Our ref: NO/2012/104392/01-L01
Your ref: 3/2012/0845

Date: 25 October 2012

LAND OFF CHAPEL CLOSE, LOW MOOR, CLITHEROE - APPLICATION FOR THE DISCHARGE OF CONDITIONS NO. 5 (SURFACE WATER DRAINAGE SCHEME); NO. 6 (SURFACE WATER REGULATION SYSTEM) AND CONDITION NO. 7 (DESK TOP STUDY) OF PLANNING PERMISSION 3/2011/0247 (CE/2011/104641/02).

Adoptable Drainage  
Layout

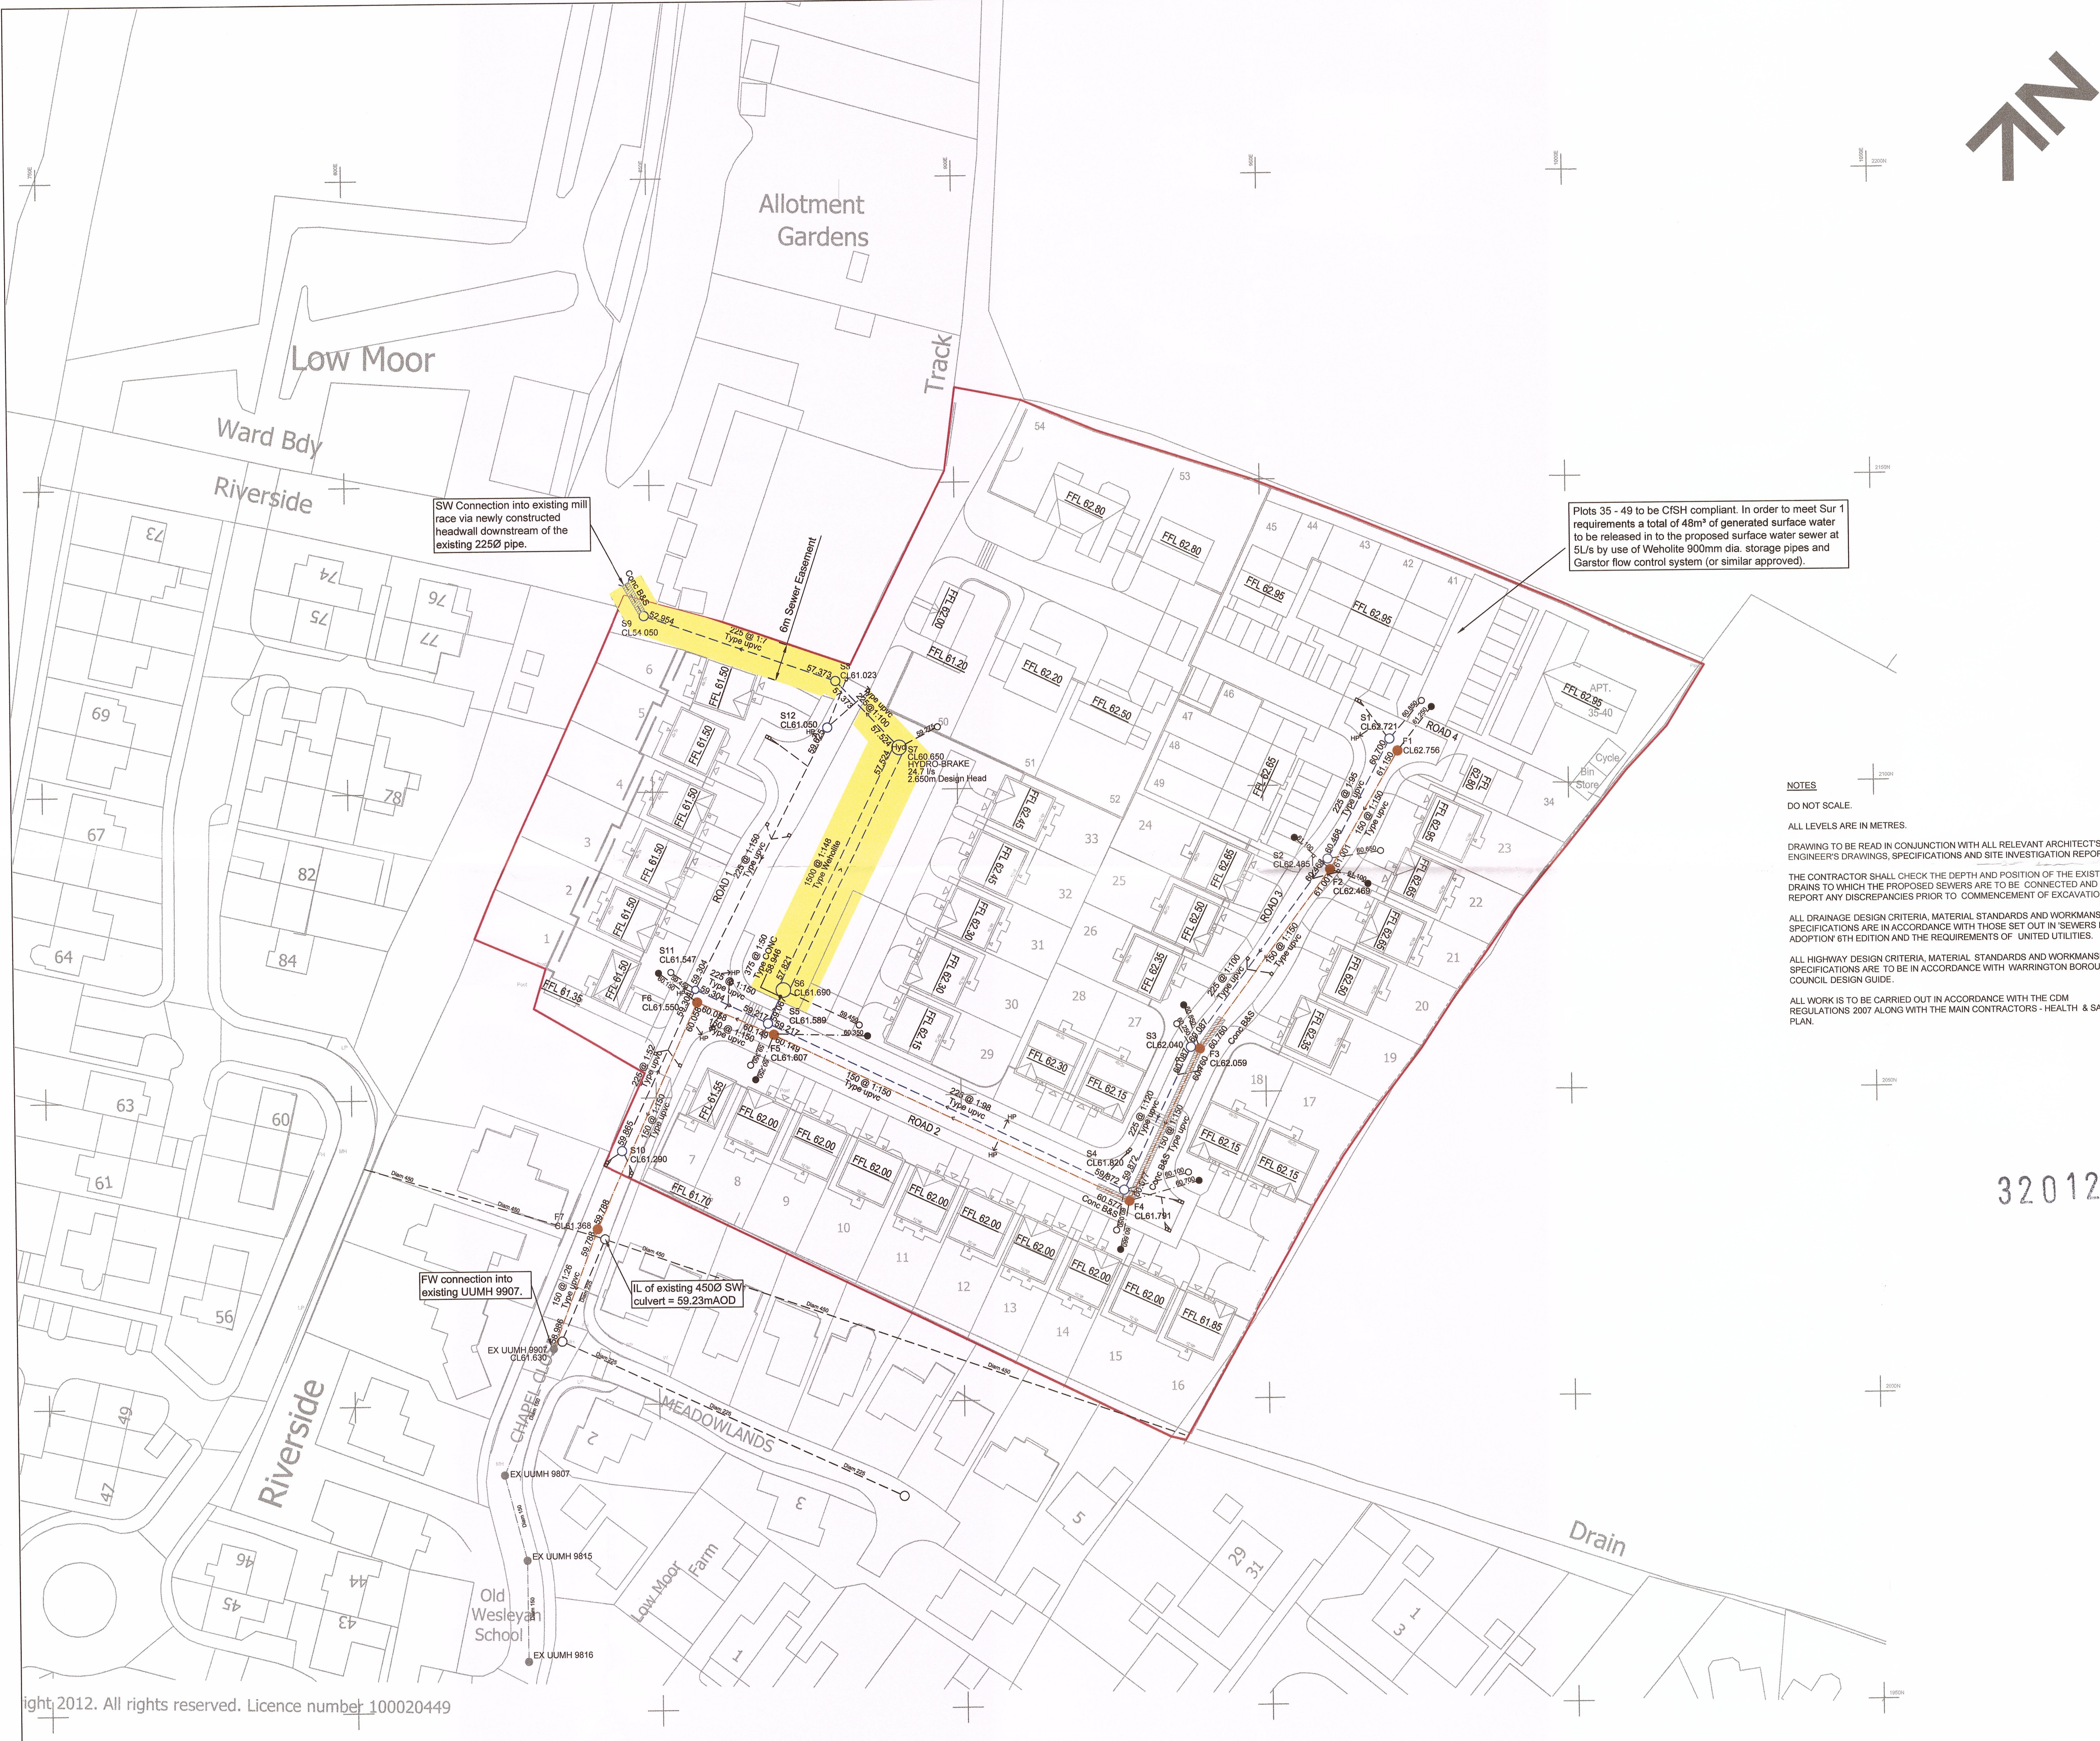
The calculations to support the scheme for surface water drainage have not been provided; it is therefore not possible to verify their accuracy or suitability of the scheme. On this basis, we recommend that the application to discharge the condition be refused.
